Landscape Design Review

Hinckley National Rail Freight Interchange (HNRFI)

Version 1.0
August 2023
Prepared by LUC

Hinckley National Rail Freight Interchange (HNRFI)
Landscape Design Review

Fig 6. Parameters Plan and Key

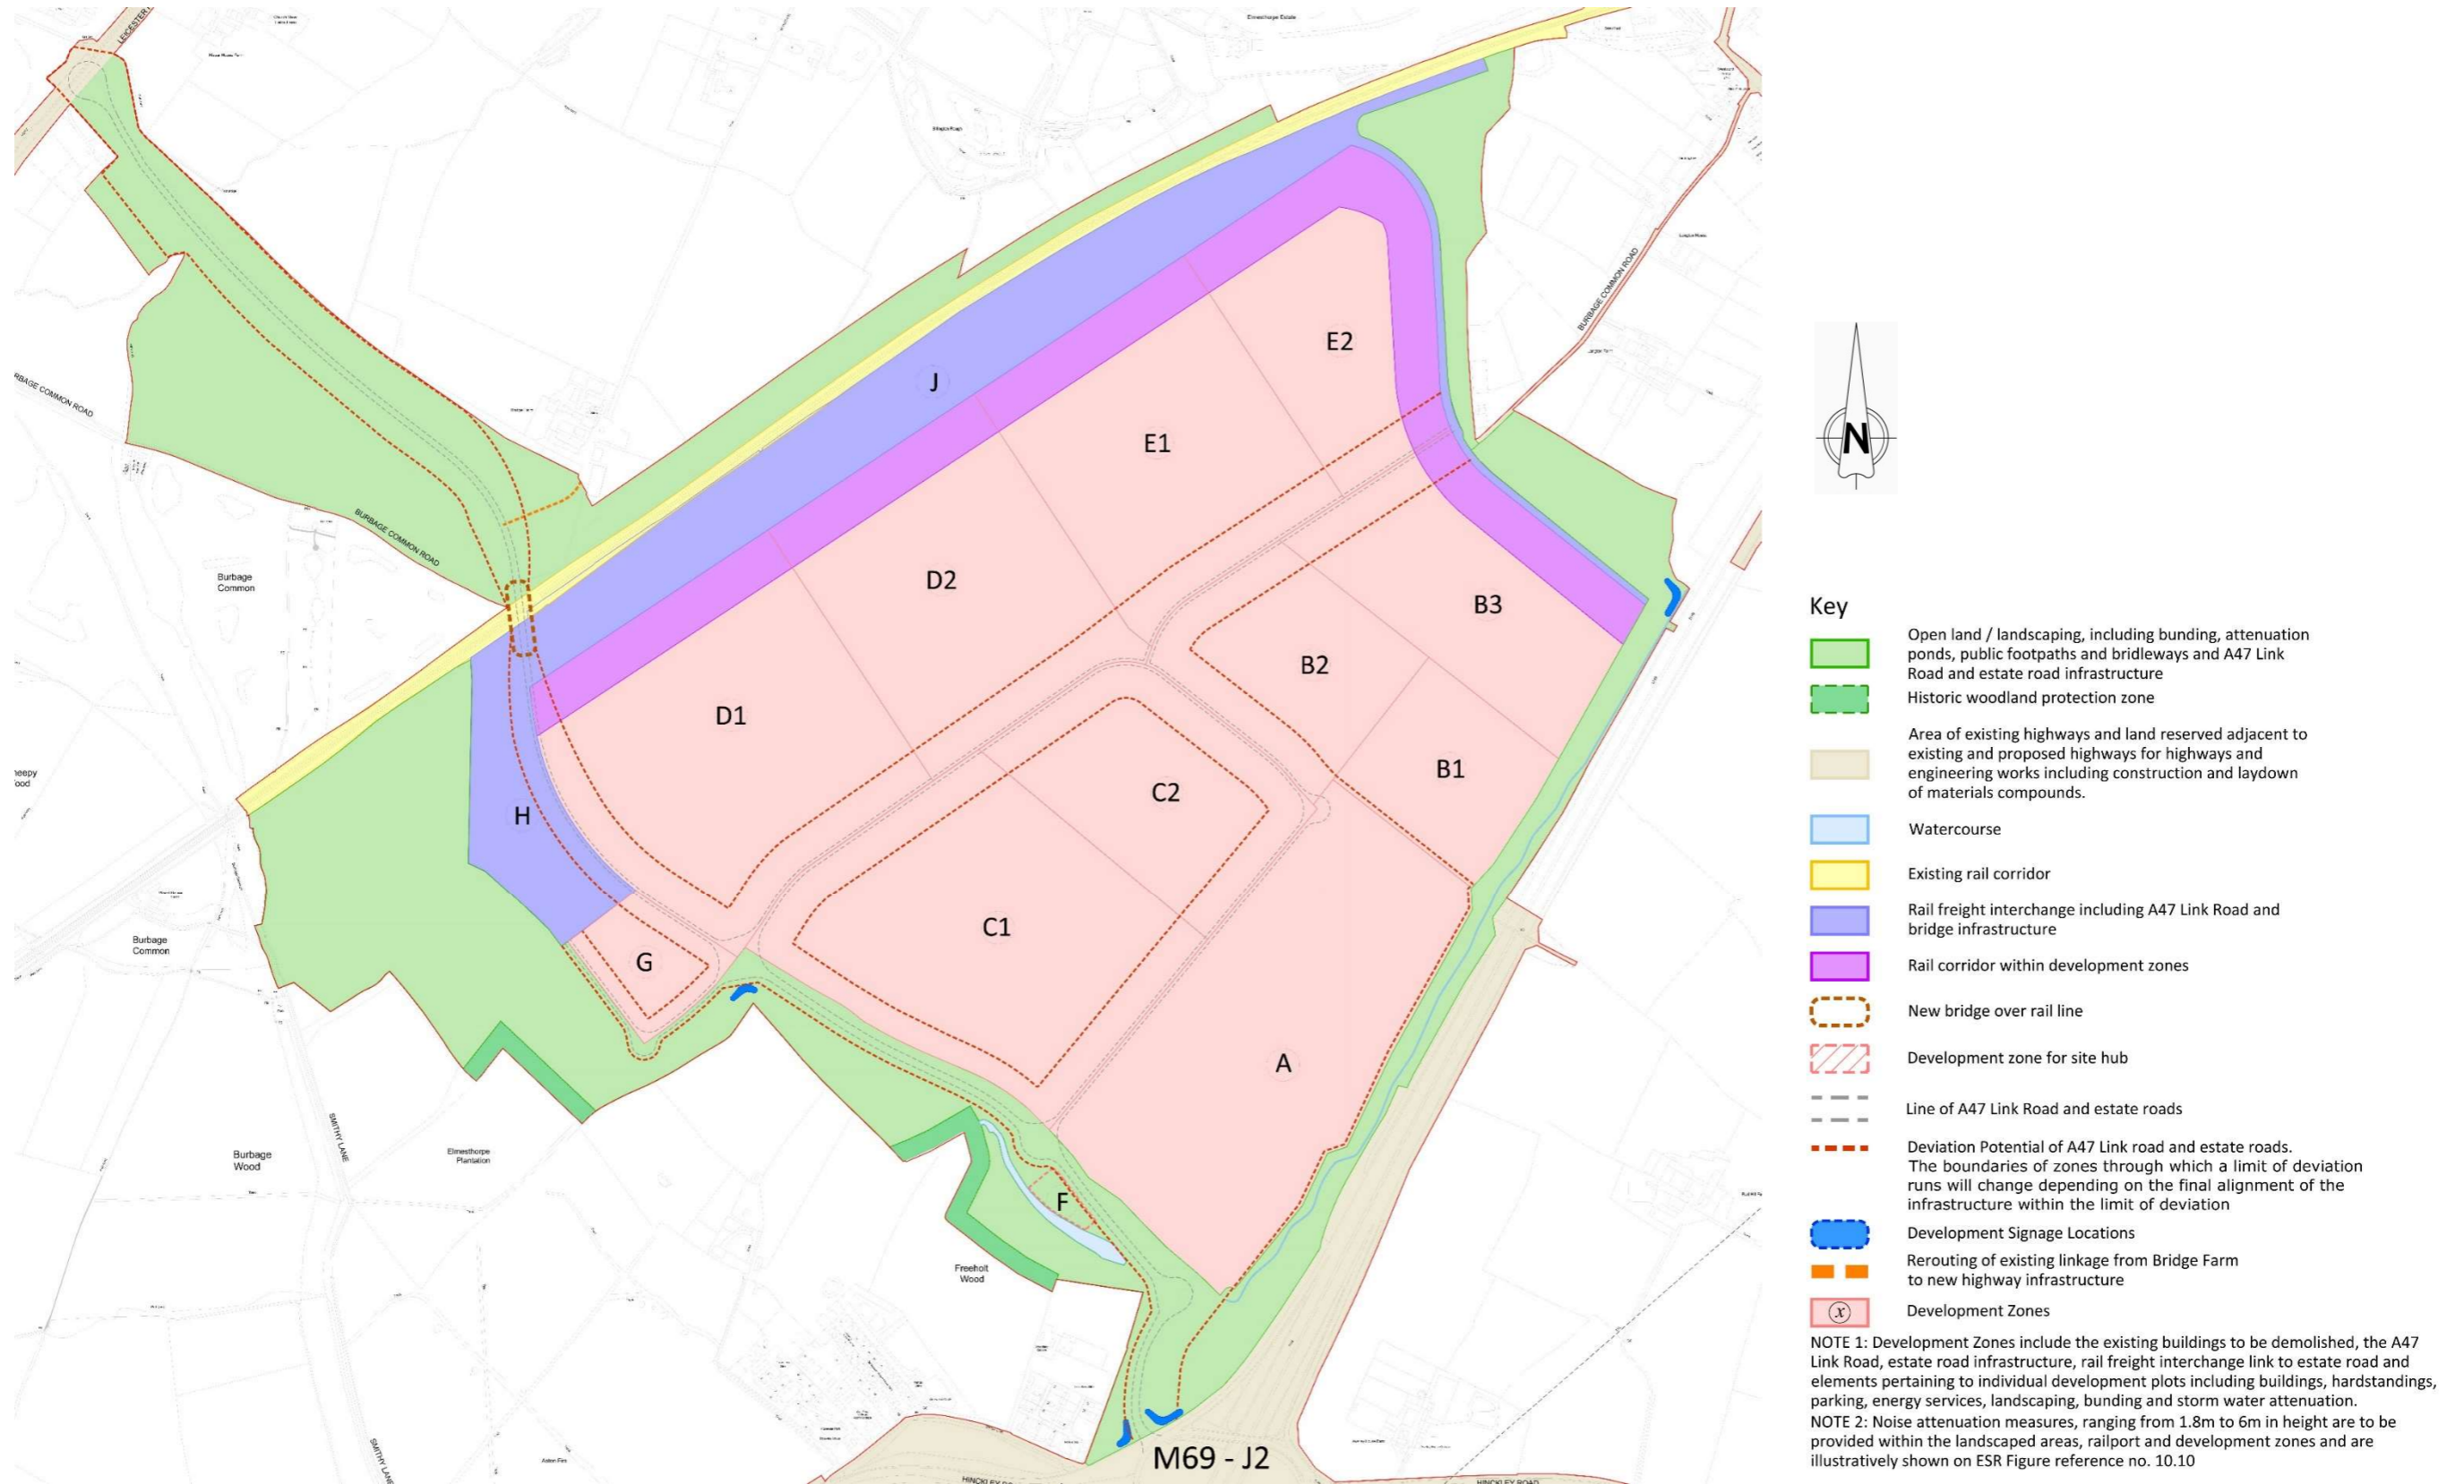
Although there has been an optioneering process to arrive at the current scheme which is welcomed, the process does not appear to have challenged the parameter plan (annex 1) which is fundamental in setting the development down it's current trajectory.

The parameter plan (Annex 1) dictates site clearance within its primary development zone. This forms the majority of the site and removes the current grain of the landscape which integrates it into its context. Without this common grain the development is rather inward looking proposing a new layout that is more uniform lacking cohesion with its surroundings.

Fig 17. Illustrative Public rights of Way

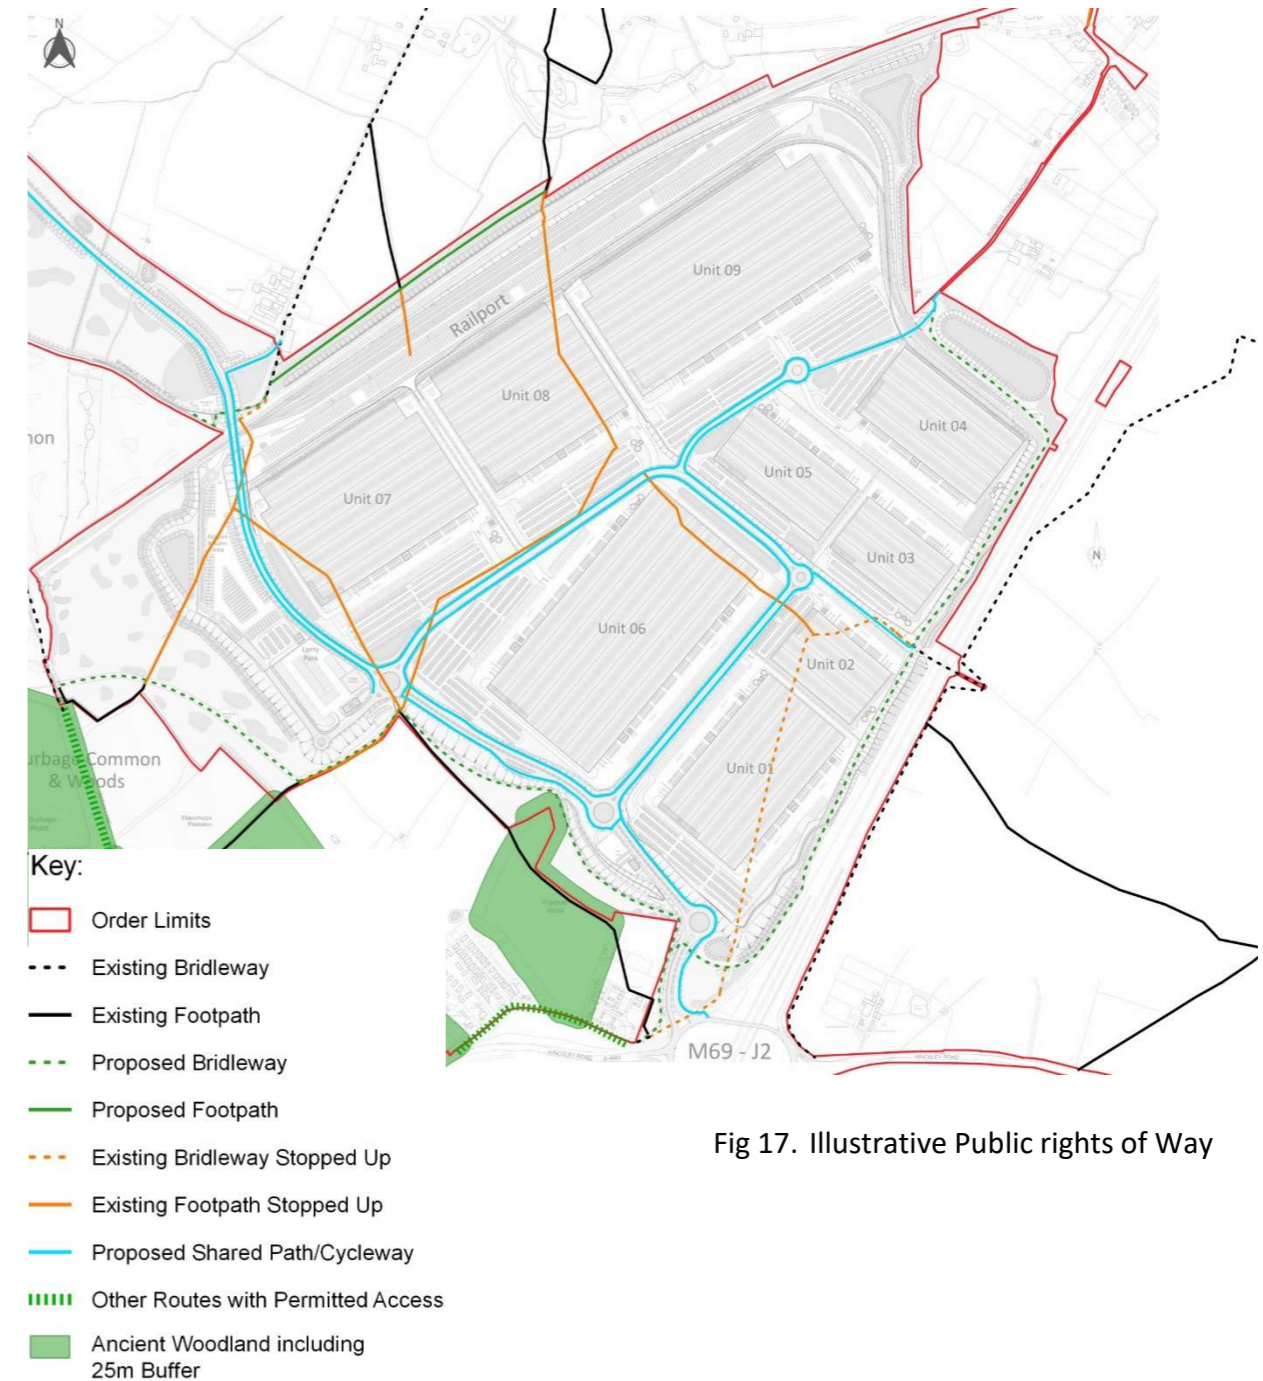
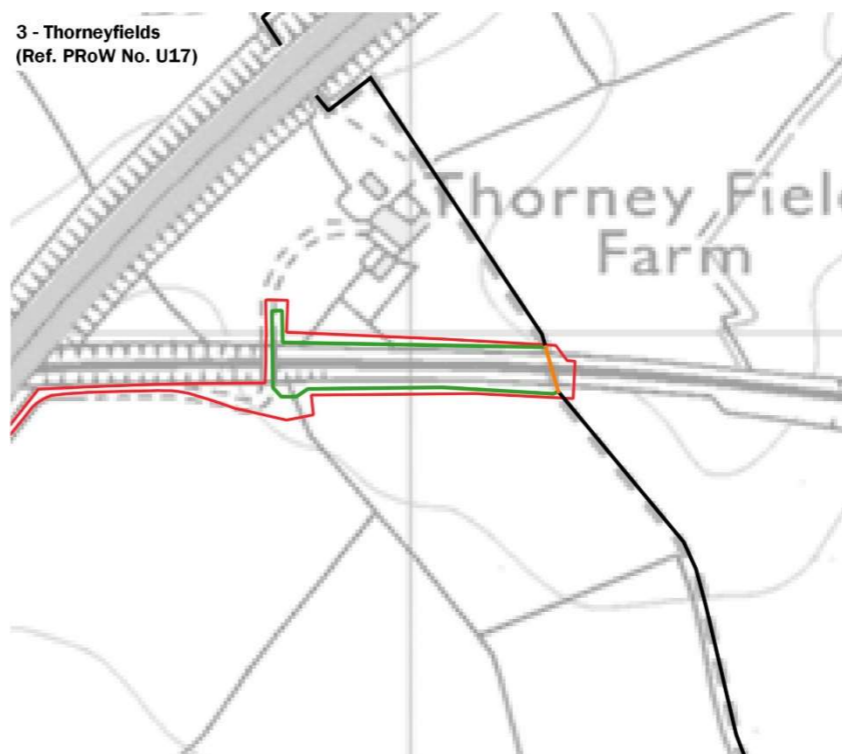
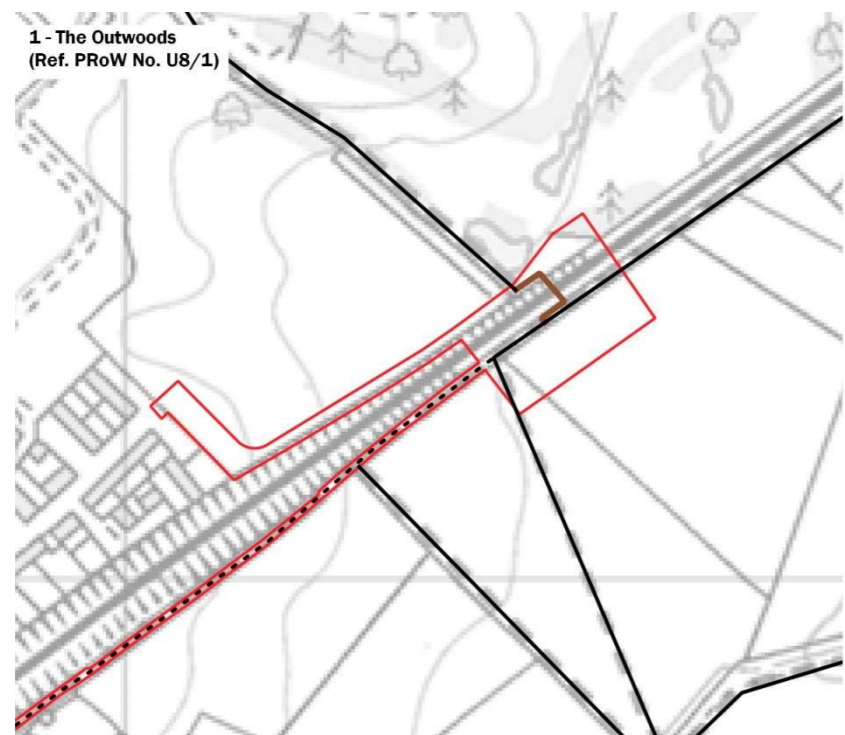
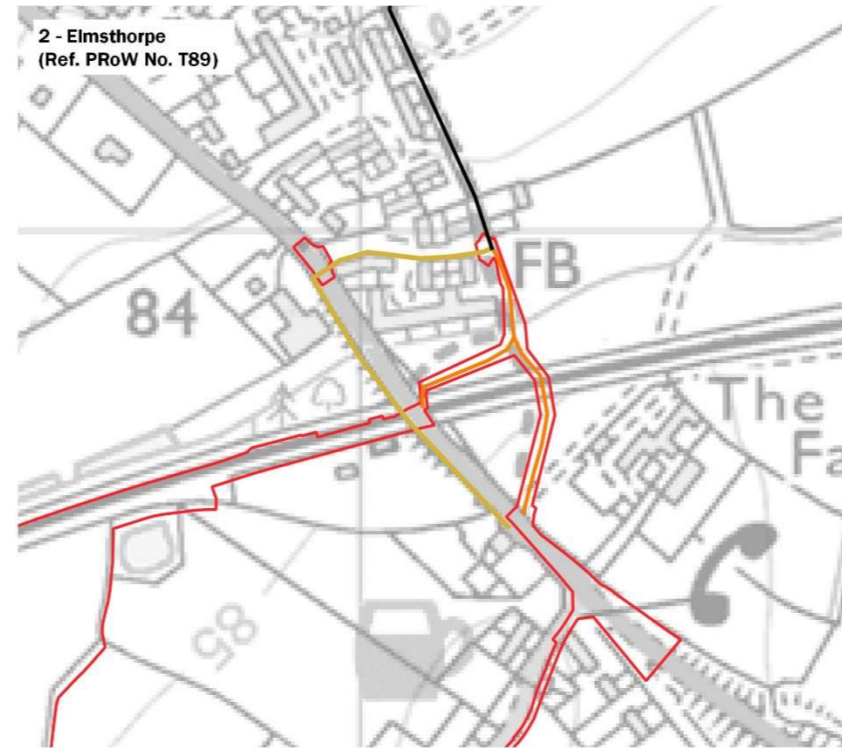
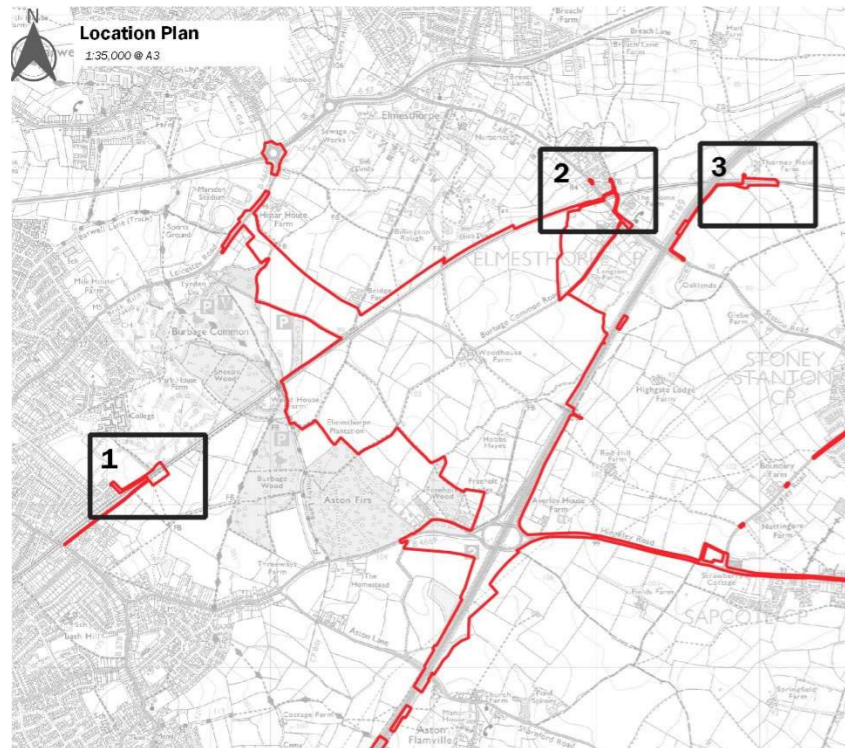
The existing public footpath and bridleways give varied rural routes permeating much of the site area. The proposals are to stop up and remove these PRow, with re-provision being on the basis of pavements and cycleways running along large main roads, which will present an entirely different character (Annex 5). A new bridleway is proposed to the south of the site away from roads, this is welcomed but does not equate to the existing provision.

The existing routes have a rural aesthetic linking towns and villages to large green infrastructure such as Burbage Common & Woods. The development changes this aesthetic and diminishes the user experience from encountering rural tracks to the proposed footpaths adjacent to roads.
